Your Ref: 2026/91628
Our Ref: B/01873

Land off Boshaw View, Hade Edge, Holmfirth HD9 2TZ - (KIRK) Erection of 17 dwellings (Use Class C3) together with associated development including access, landscaping, ancillary infrastructure and parking

1.) The layout details submitted on drawing 'PRELIMINARY DRAINAGE STRATEGY' 166337-SAN-DRH-NTH-DR-C-05_001 (revision P04) dated 06/03/26 that has been prepared by Sanderson require amendments. The following point(s) should be addressed:

Proposed Site Layout

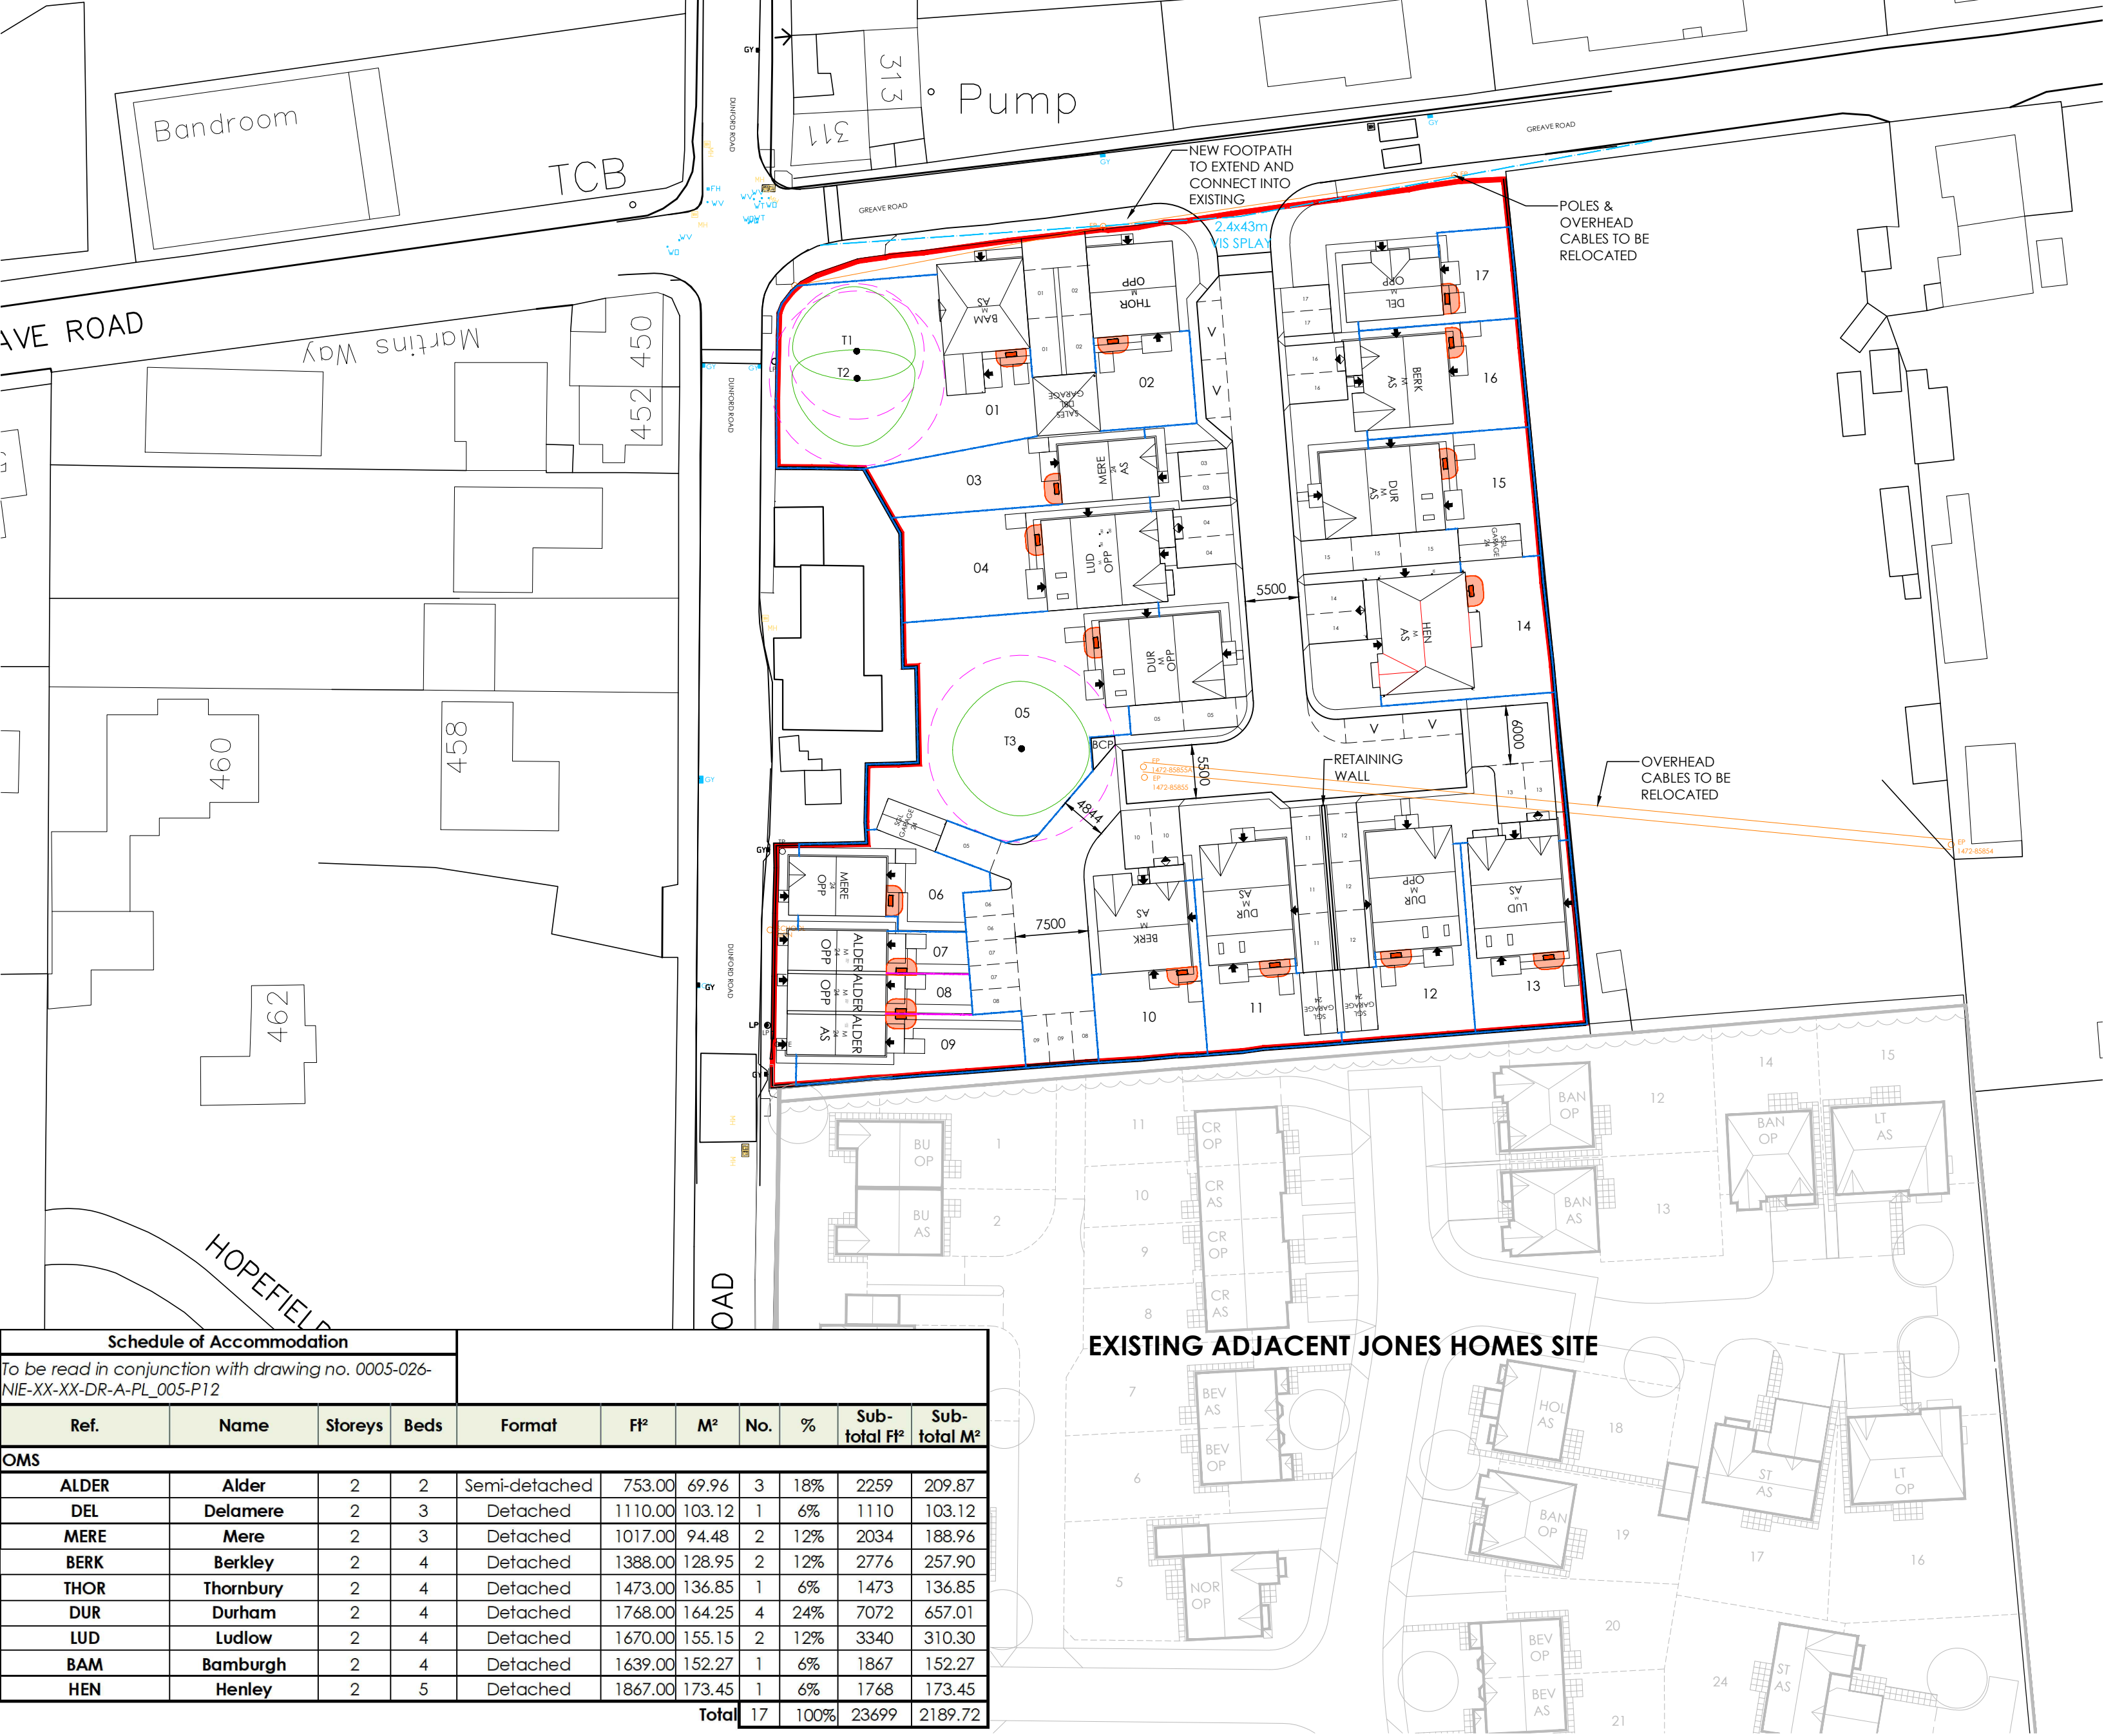
NOTE- it appears from the submitted site layout that buildings will be sited over the public sewerage system located within the site. This could seriously jeopardise Yorkshire Water's ability to maintain the public sewerage network and is not acceptable. We therefore OBJECT to the development layout as currently shown. I strongly advise that, prior to determination of this application, the site layout is amended to allow for adequate protection of the sewers. For further information, the developer should contact our Developer Services Team: telephone 0345 120 84 82 (option 1) or email technical.sewerage@yorkshirewater.co.uk.

- a.) the submitted drawing map (potentially) shows a building or soakaway proposed to be built-over the line of public sewer crossing the site.
- b.) the submitted drawing should show the site-surveyed position of the public sewer crossing the site.
- c.) the submitted drawing should show the required building stand-off from public sewer -- or an agreed alternative scheme under H4 (whichever is appropriate)

It has been reported that an unmapped public sewer (possible adopted through TBT 2011 legislation) run through the site. This sewer is likely a 100-150mm public combined water sewer connecting from the manhole at the rear of 232 Dunsford Road, and runs to the north east, to the public combined water manhole on Greave Road circa 414571, 405500.

The developer is required to carry out a site survey to confirm the positions, and make appropriate measure that the sewer is protected from the proposed development.
